CITY OF ALBUQUERQUE

**Re: Journal Center Lot 1, 7400 Washington St NE, Traffic Circulation Layout
Engineer's Stamp dated 2-16-05 (D17-D3AA3)**

Based upon the information provided in your submittal received 2-16-05, the above referenced plan cannot be approved for Building Permit until the following comments are addressed:

SITE PLAN

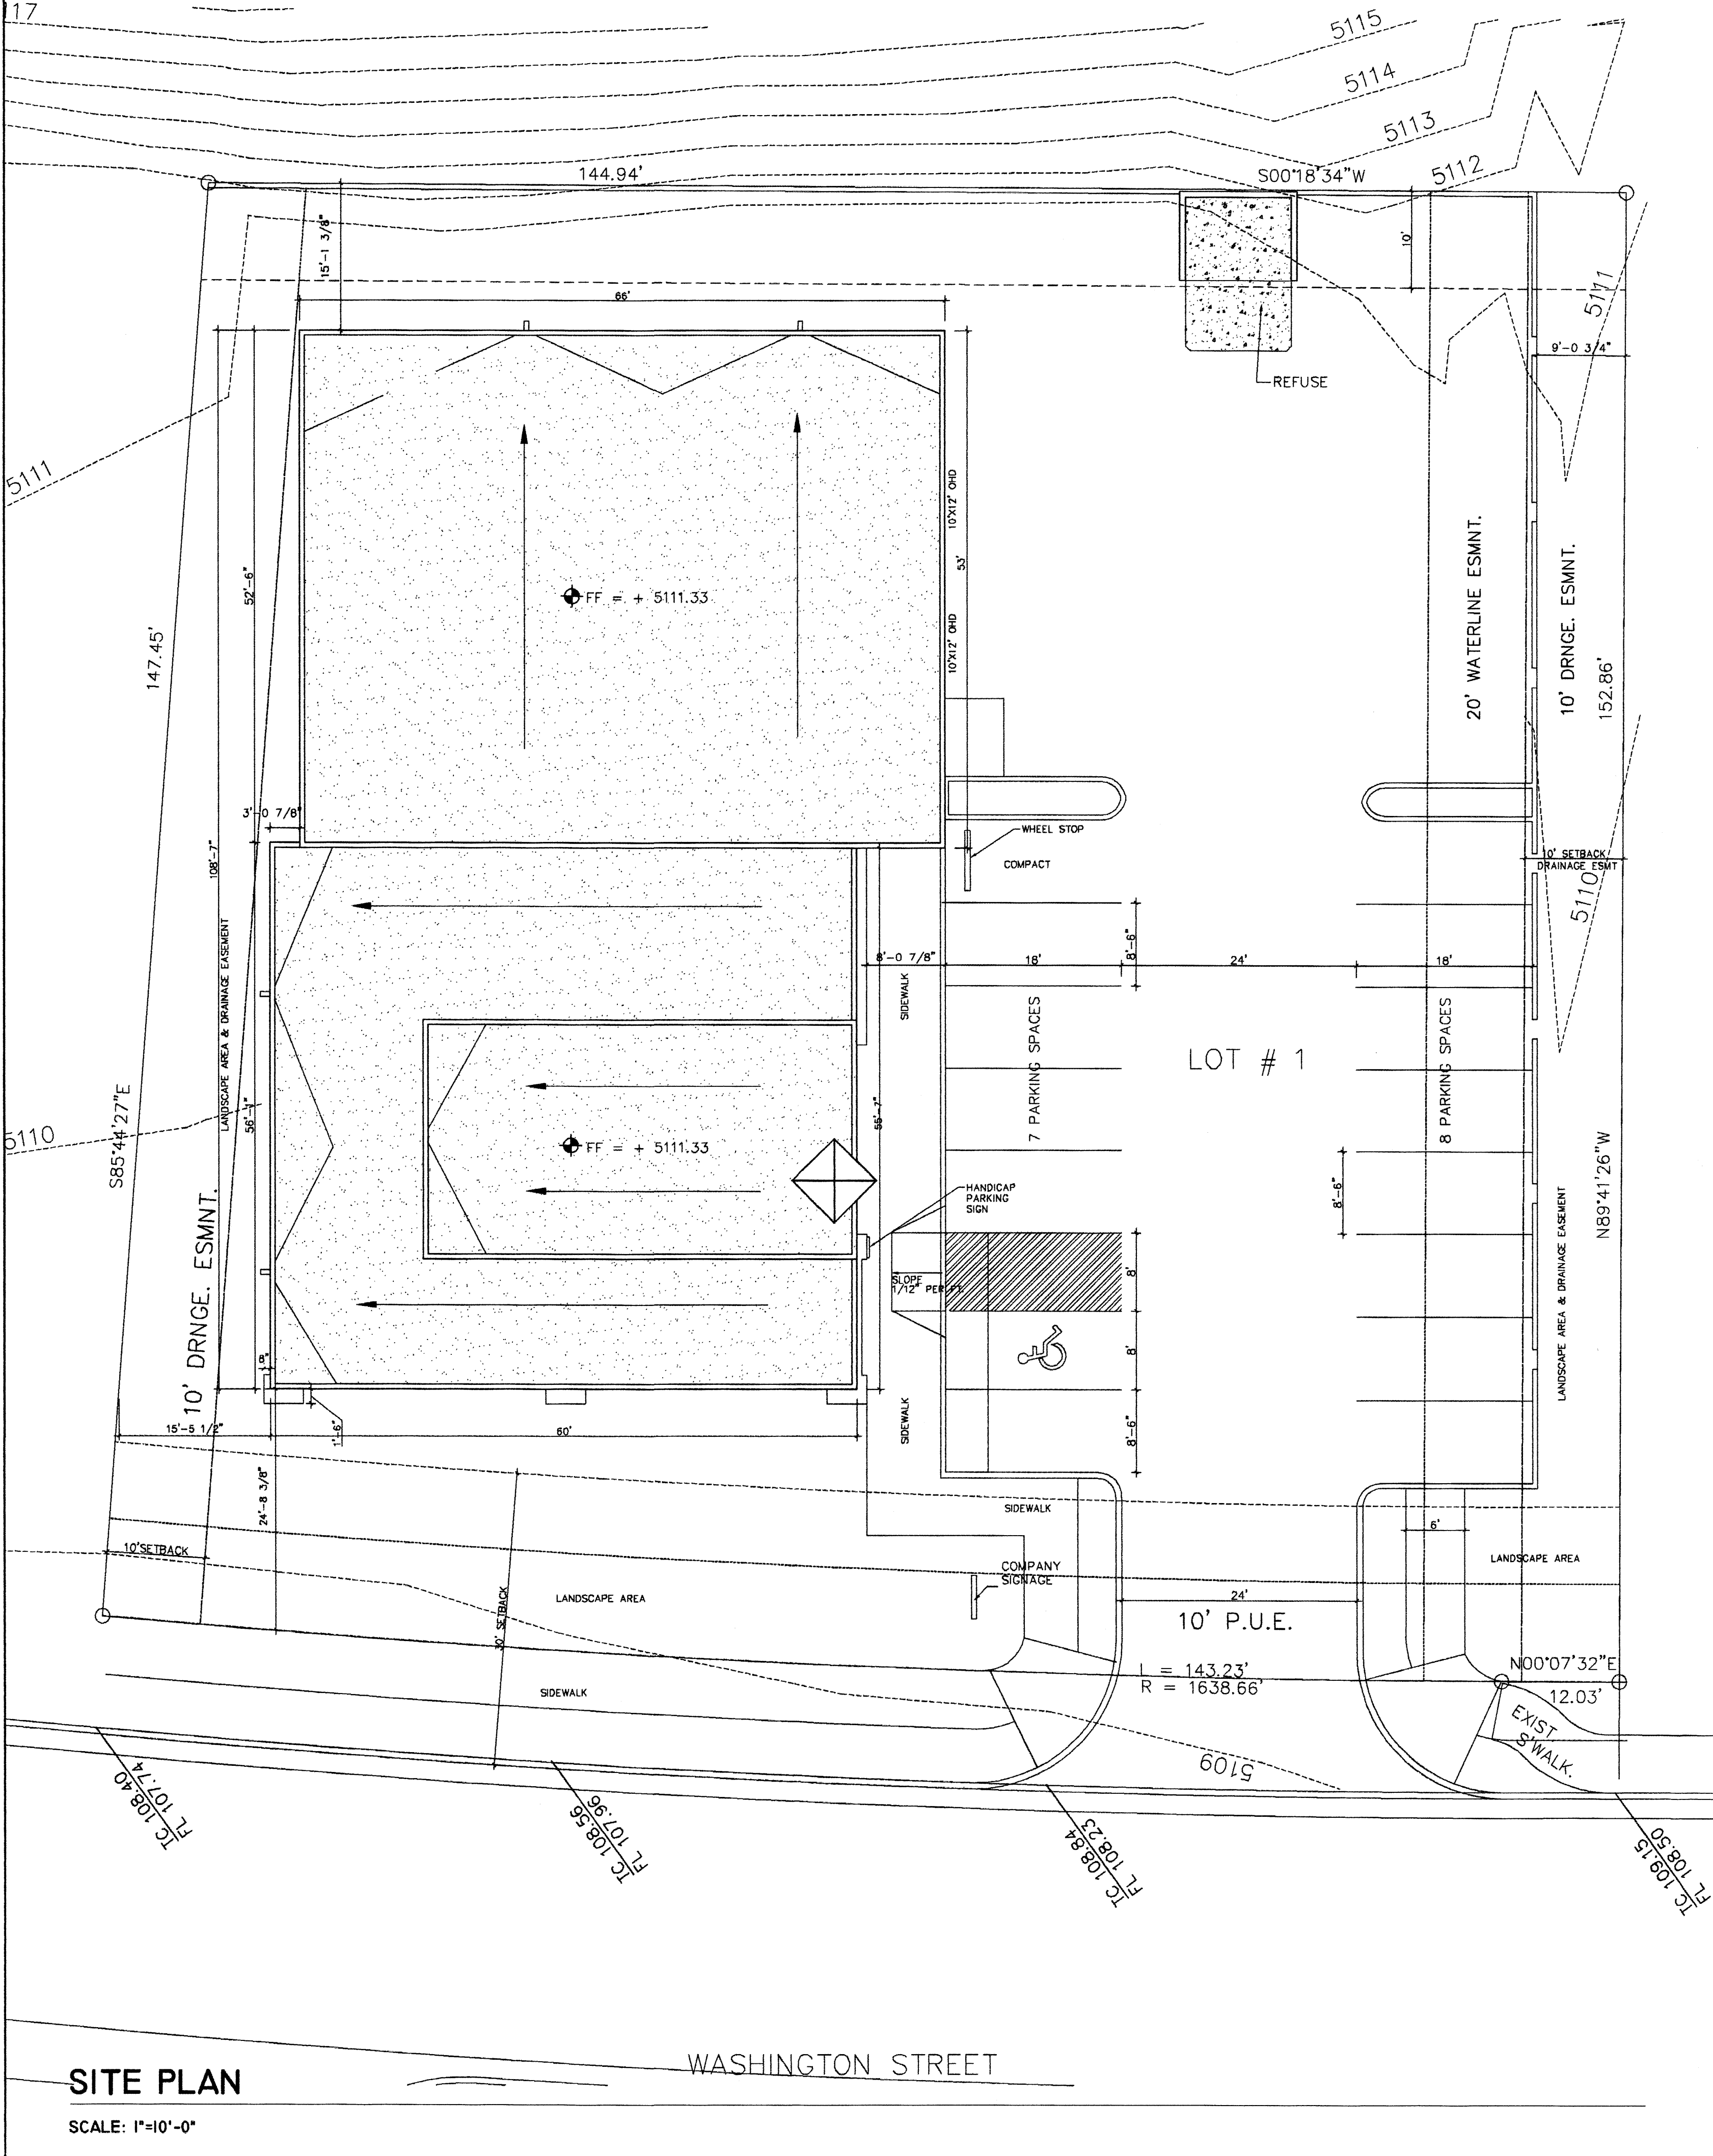
1. List radii for all curves shown.
2. Define the width of all sidewalk.
3. Is the driveway shown existing or proposed?
